CITY OF ALBUQUERQUE

December 2, 2011

**Re: Country Club Place, 1816 Central Ave SW, (J13/D011),
Permanent Certificate of Occupancy - Approved
Approved Engineer's Stamp date: 4/5/11,
Certification dated: 12-1-11**

IS AN INFRASTRUCTURE LIST REQUIRED? ( ) YES ( ) NO IF YES, THEN A SET OF APPROVED DRC PLANS WITH A WORK ORDER IS REQUIRED FOR ANY CONSTRUCTION WITHIN PUBLIC RIGHT-OF-WAY OR FOR CONSTRUCTION OF PUBLIC IMPROVEMENTS.

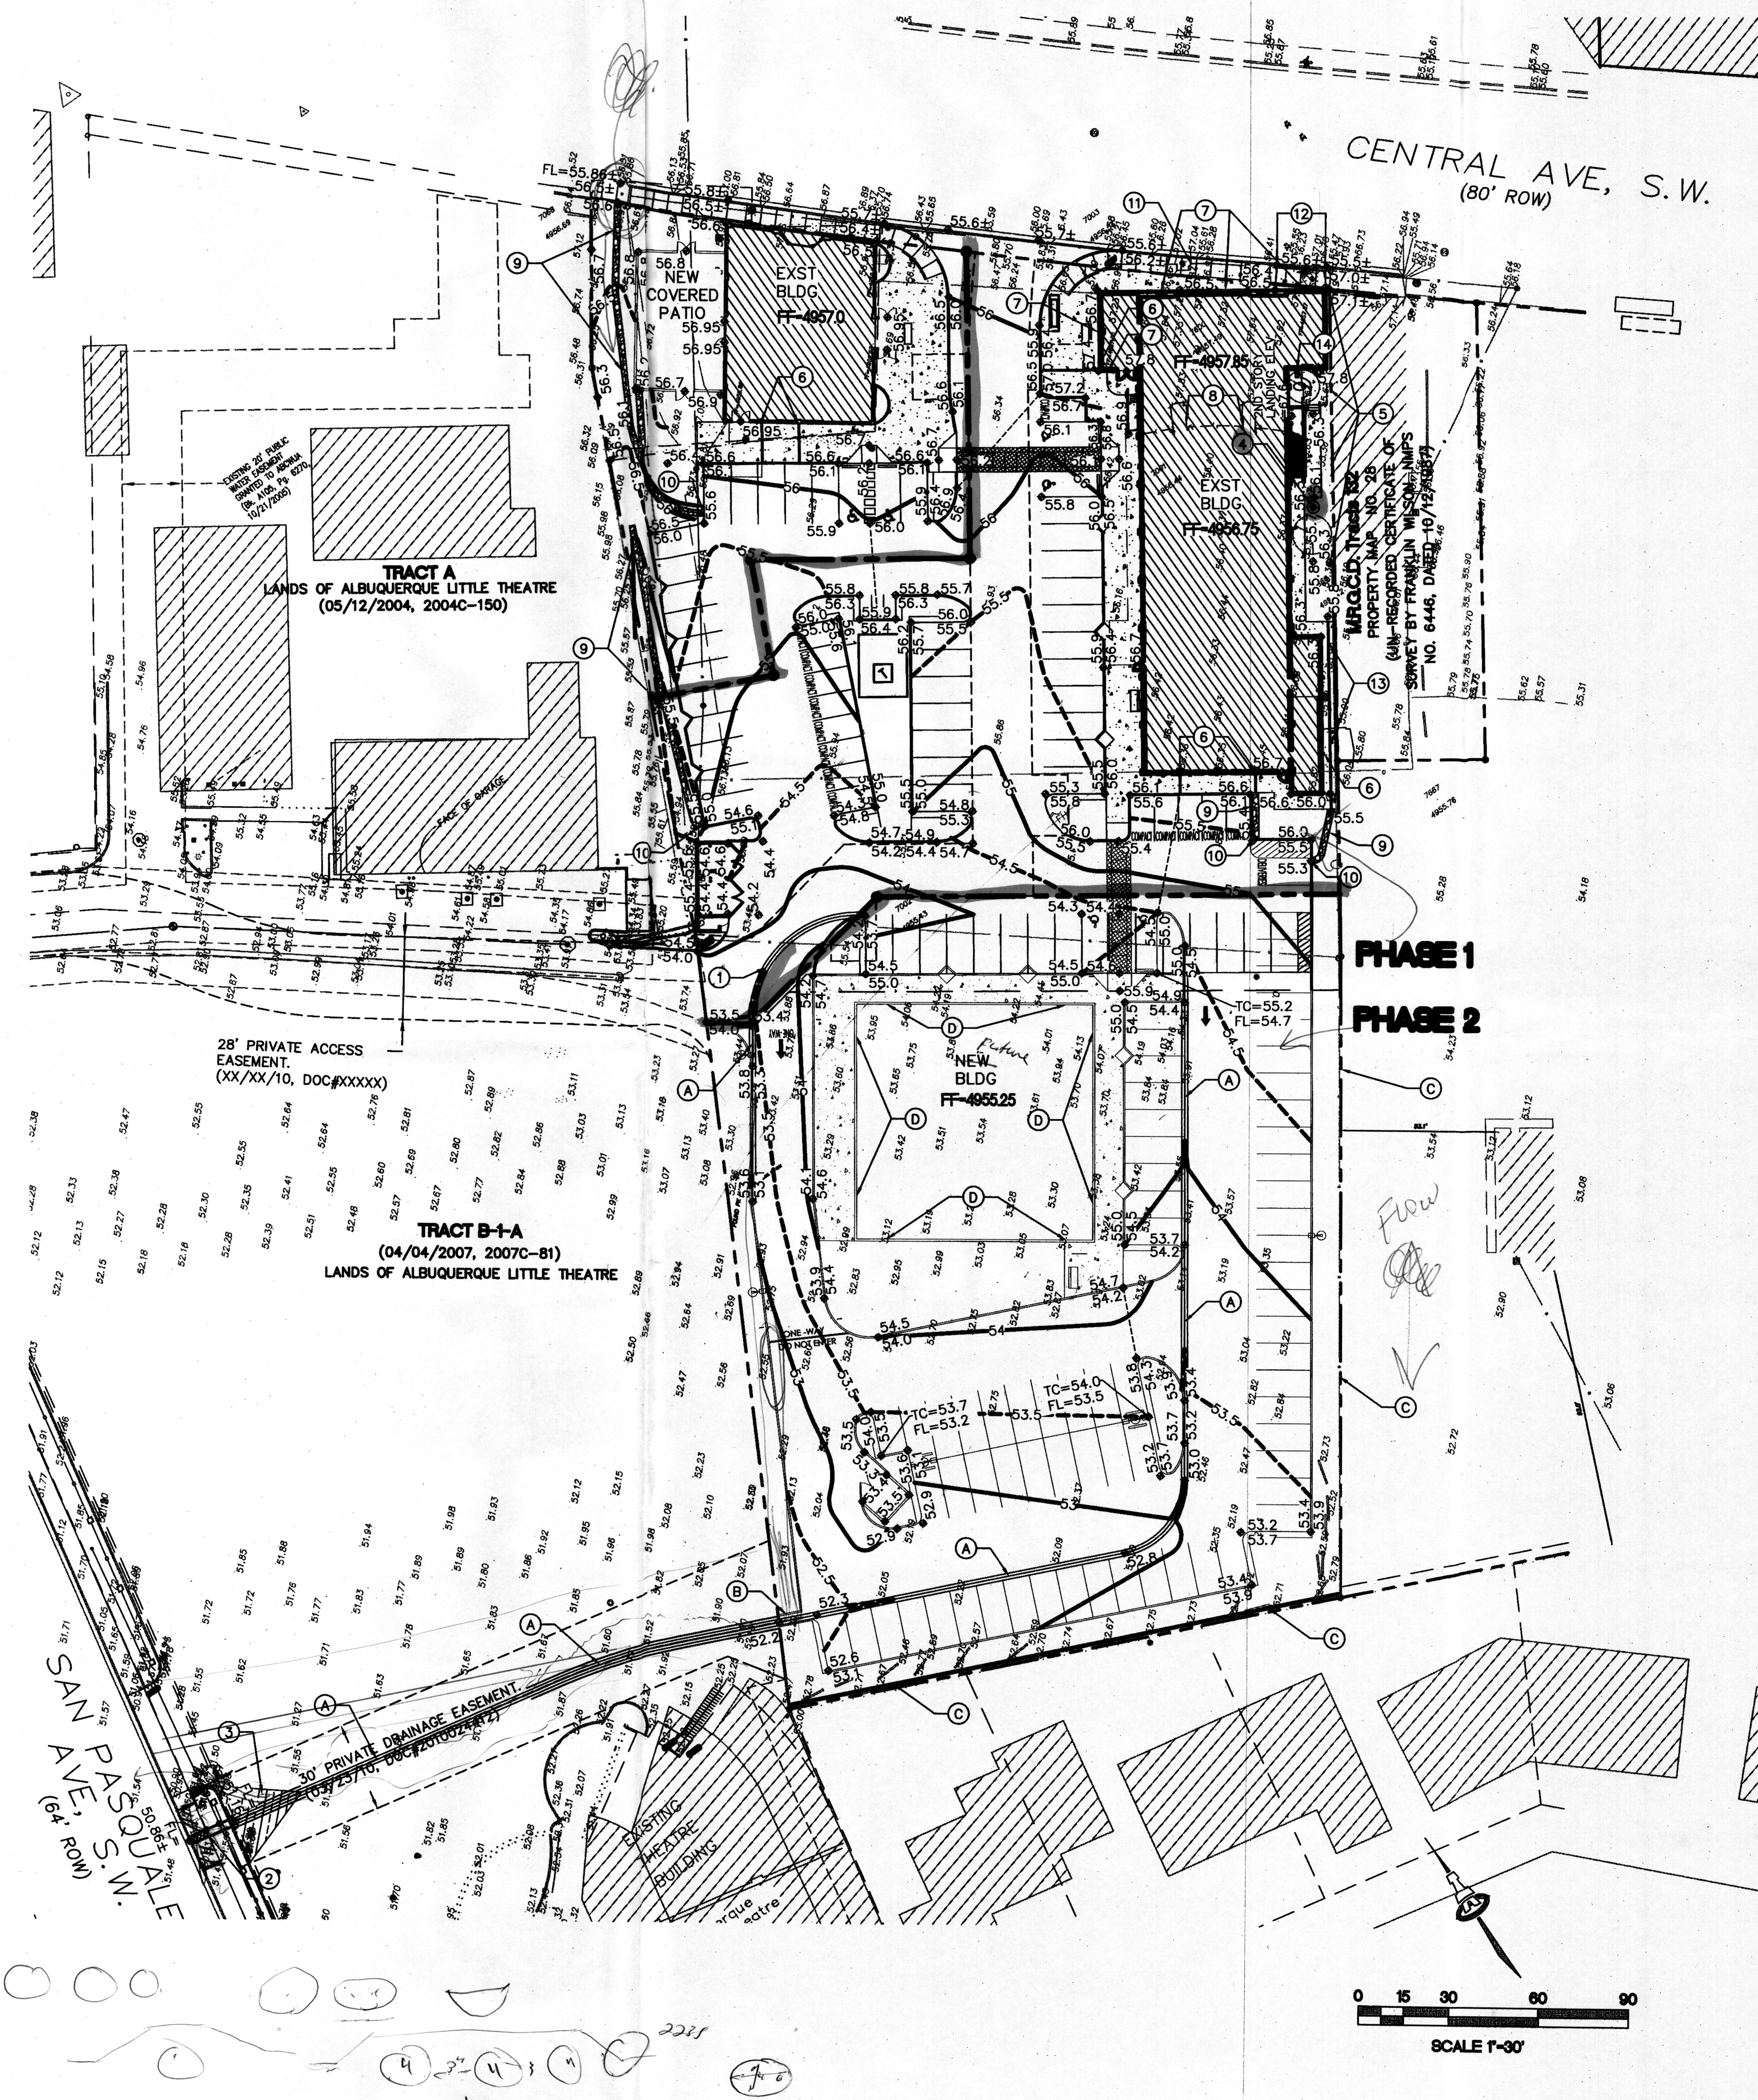
- The drainage addressed in Certification Note 2 is to drain south or an easement and capacity analysis to drain west/not per plan is required.
- Keyed Note 13 is to be changed to what is built or the trench drain is to be built.
- The sidewalk culvert on San Pasquale is to be constructed.
